Rev.	Date	Description	Drawn	Checked
Client		dandara	Scale	1:100 @ A3
Project		Fontwell, West Sussex.	Drawn	TM
Drawing Title		Type 302A - Style Ref 1	File	Type 302A
Floor & Roof Plans - (Brick)		Drg.No. P1549.302A.17	Rev.	-
			Drawing Status	PLANNING

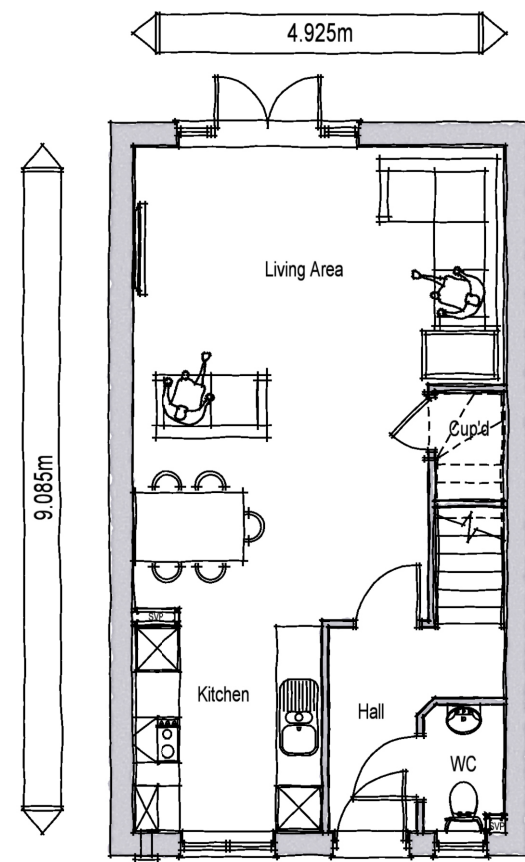
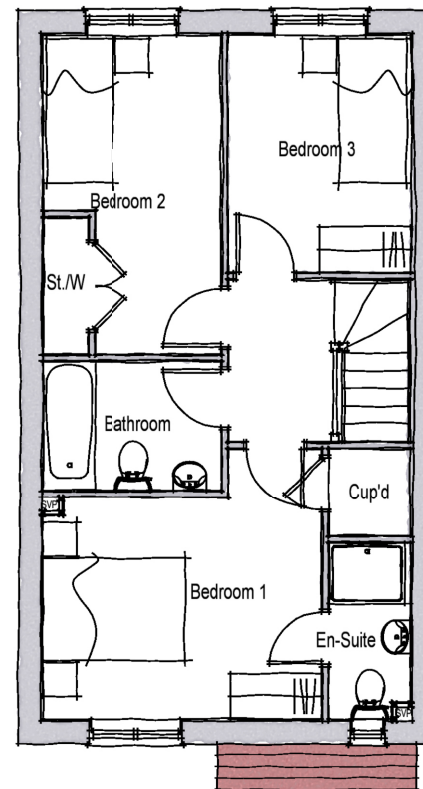
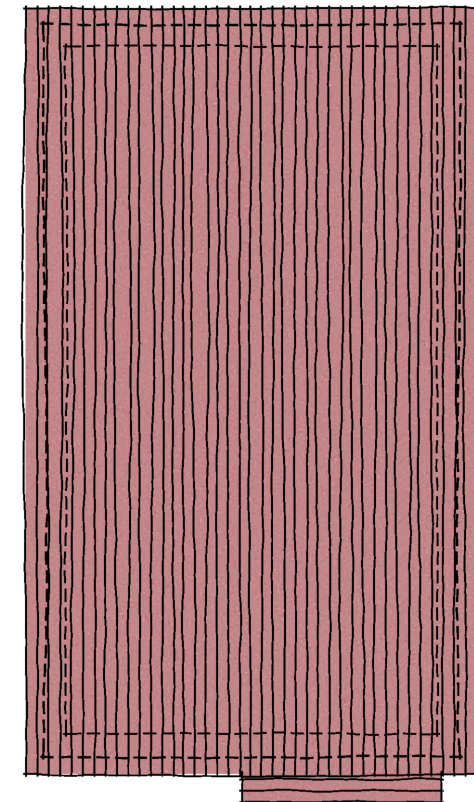
The following drawings do not accord and will required updated plans to be submitted.

P1549.302A.17 & P1549.302.A.18

Rev.	Date	Description	Drawn	Checked
Client			Scale	1:100 @ A3
Project		Fontwell, West Sussex.	Date	March 2019
Drawing Title		Type 408 - Style Ref 3	File	Type 408
		Rear & Side Elevations - (Brick)	Drg.No.	P1549.408.03
			Rev.	-
			Drawing Status	PLANNING

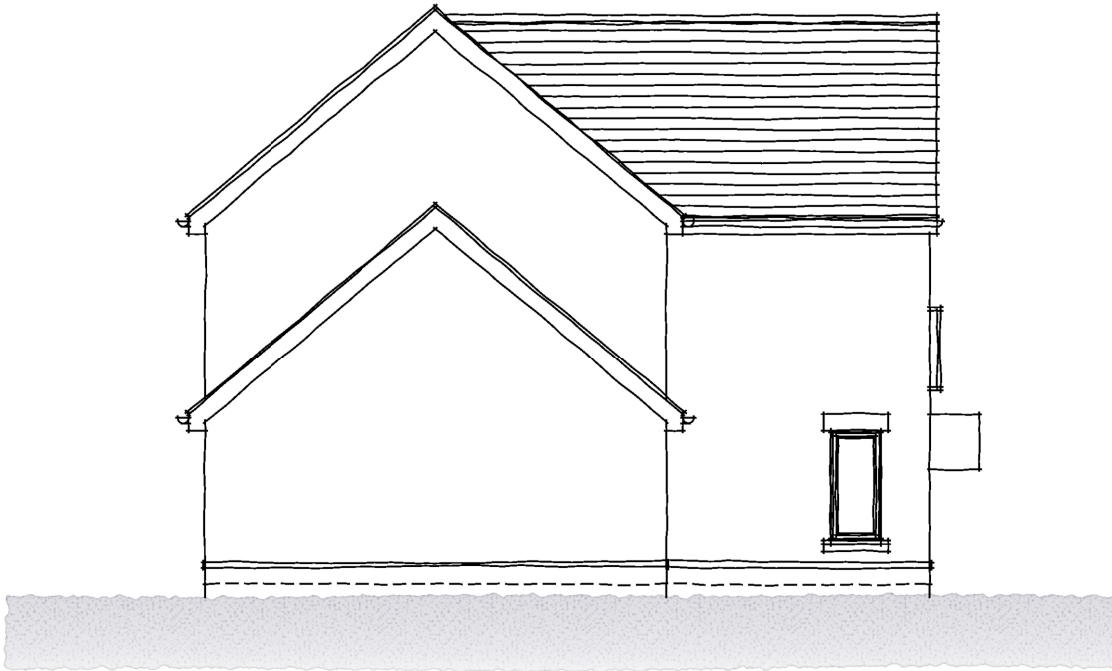
P1549.408.01 & P1549.408.03

Rev.	Date	Description	Drawn	Checked
Client		dandara	Scale	1:100 @ A3
Project		Fontwell, West Sussex.	Drawn	TM
Drawing Title		Type 408 - Style Ref 3	Checked	DGP
Floor & Roof Plans - (Boarding)			File	Type 408
			Drg.No.	P1549.408.04
			Rev.	-
			Drawing Status	PLANNING

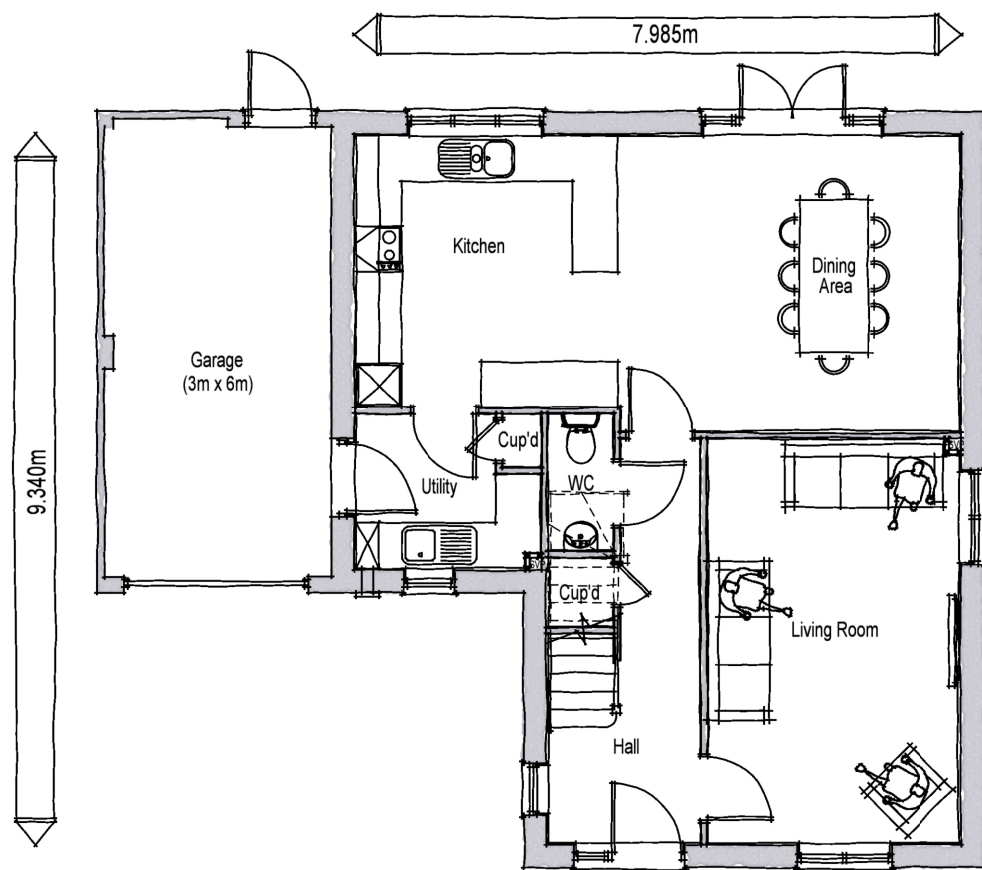
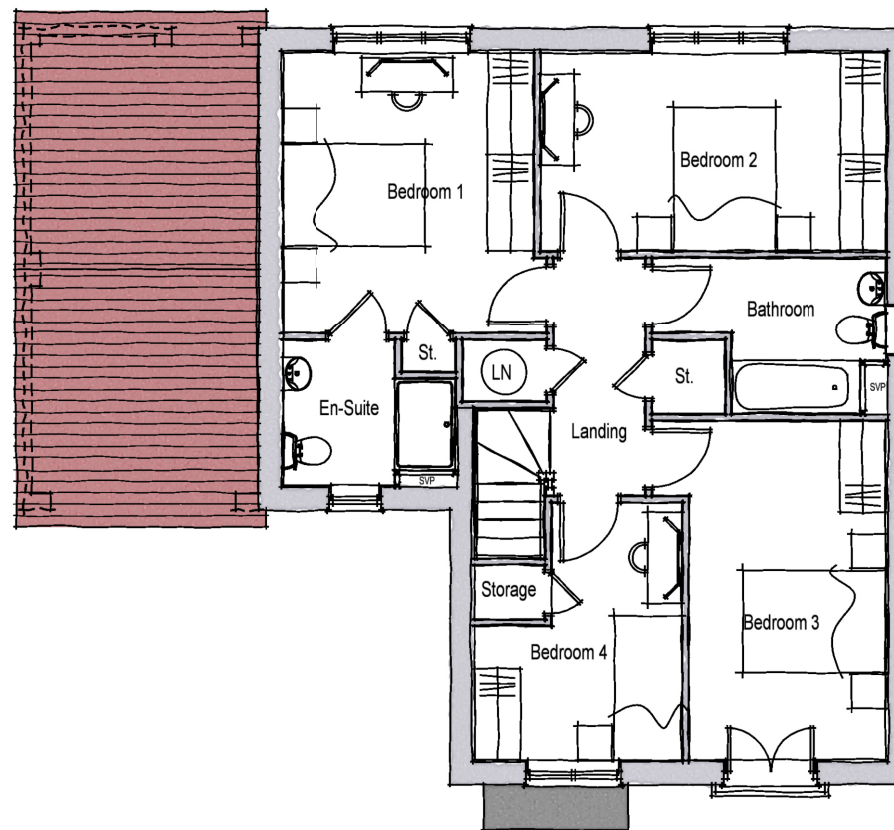
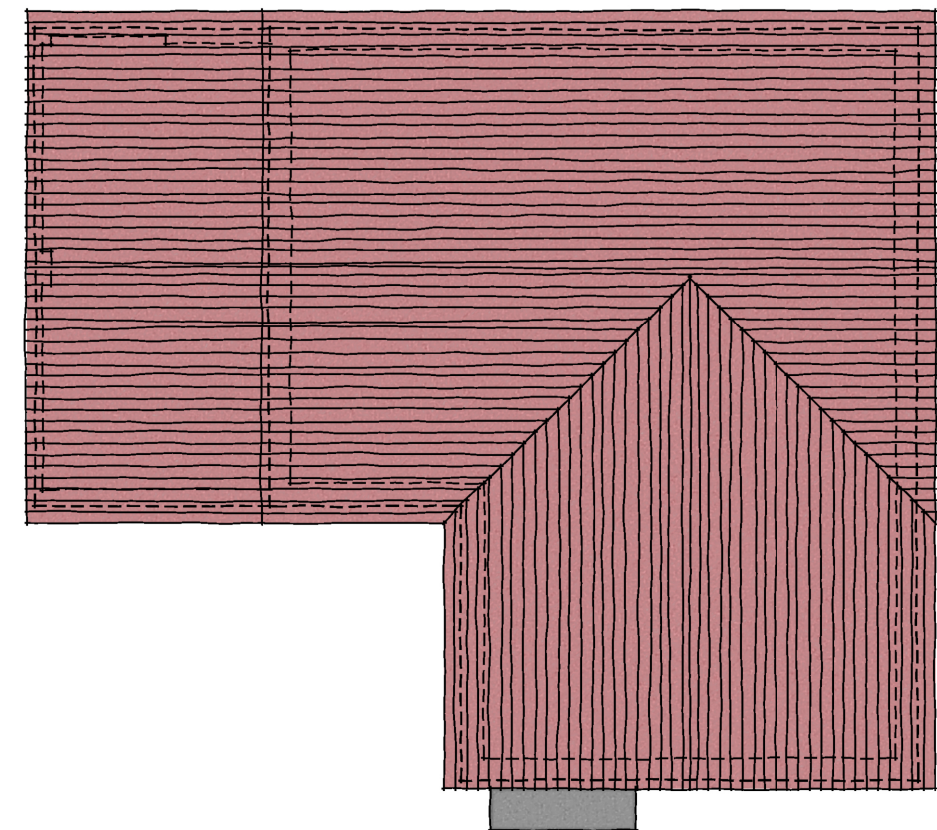
P1549.408.04 & P1549.408.06

Rev.	Date	Description	Drawn	Checked
Client			Scale	1:100 @ A3
Project	Fontwell, West Sussex.		Drawn	TM
Drawing Title	Type 408 - Style Ref 4		Checked	DGP
Front & Side Elevations - (Boarding)	Date	March 2019	File	Type 408
	Drg.No.	P1549.408.08	Rev.	-
			Drawing Status	PLANNING

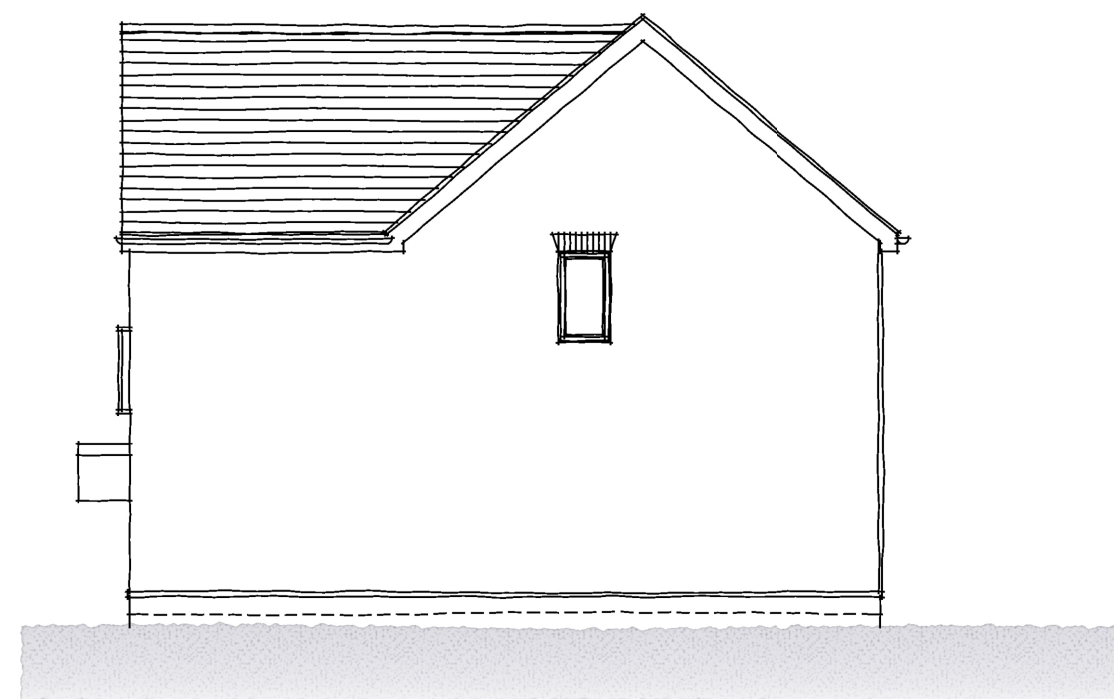
P1549.408.07 & P1549.408.08 & P1549.408.09

Rev.	Date	Description	Drawn	Checked
Client		dandara	Scale	1:100 @ A3
Project		Fontwell, West Sussex.	Date	March 2019
Drawing Title		Type 408 - Style Ref 2	File	Type 408
		Front & Side Elevations - (Boarding)	Drg.No.	P1549.408.11
			Rev.	-
			Drawing Status	PLANNING

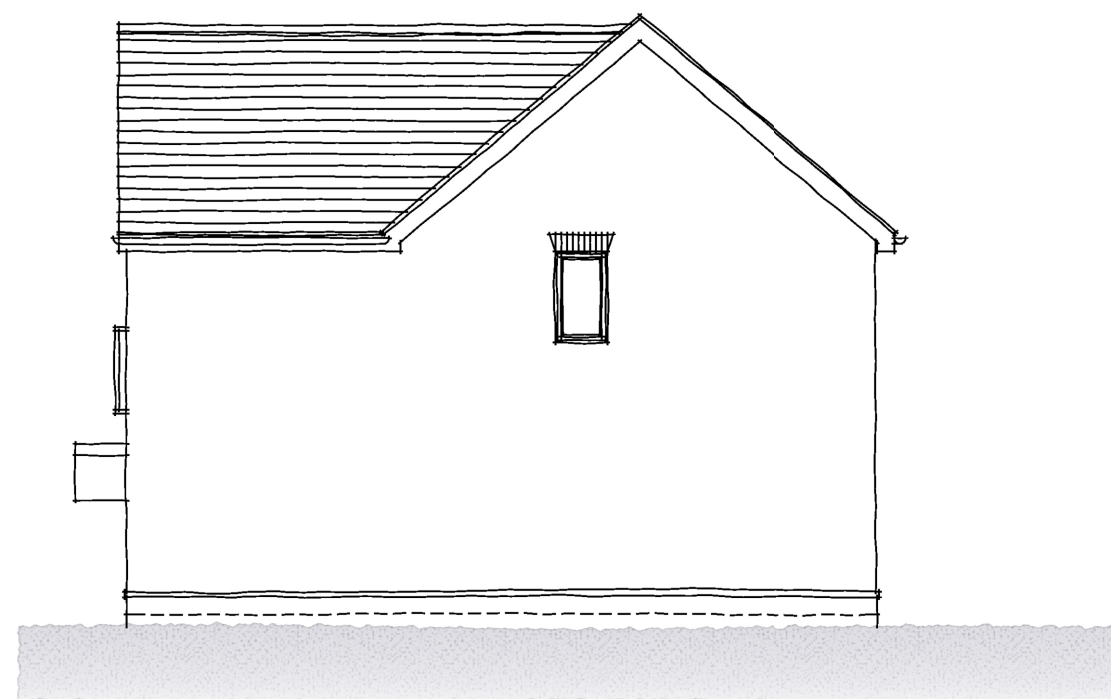
P1549.408.10 & P1549.408.11 & P1549.408.12

Rev.	Date	Description	Drawn	Checked
Client			Scale	1:100 @ A3
Project	Fontwell, West Sussex.		Drawn	TM
Drawing Title	Type 408 - Style Ref 1 Front & Side Elevations - (Brick)		Checked	DGP
Date	March 2019		File	Type 408
Drg.No.	P1549.408.14		Rev.	-
			Drawing Status	PLANNING

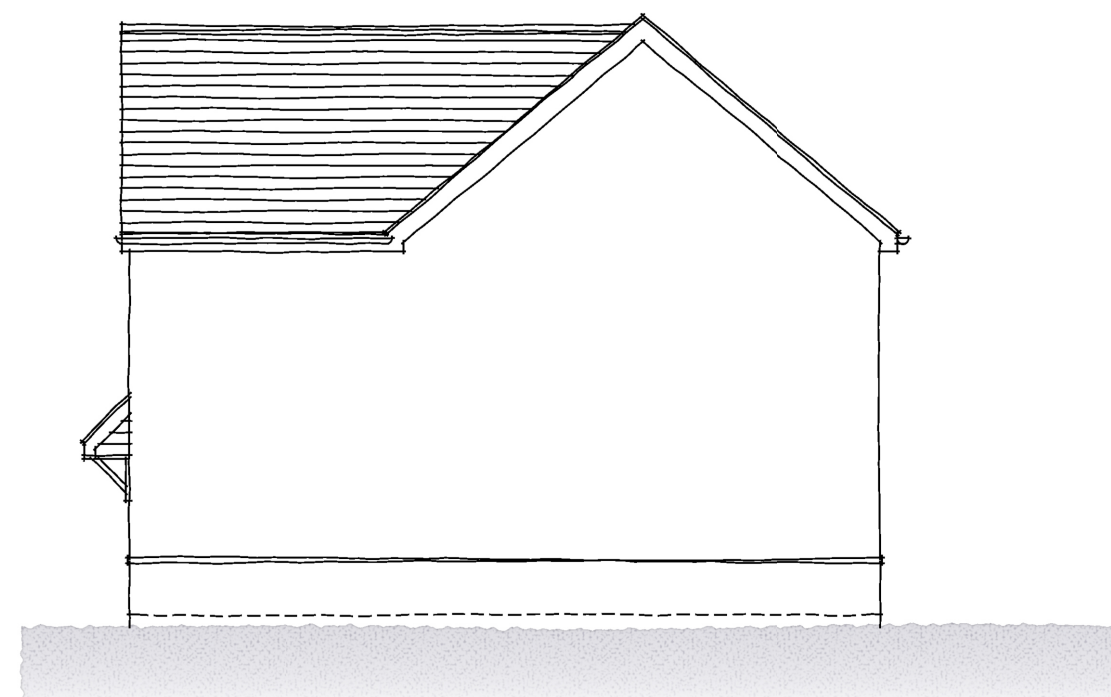
P1549.408.13 & P1549.408.14
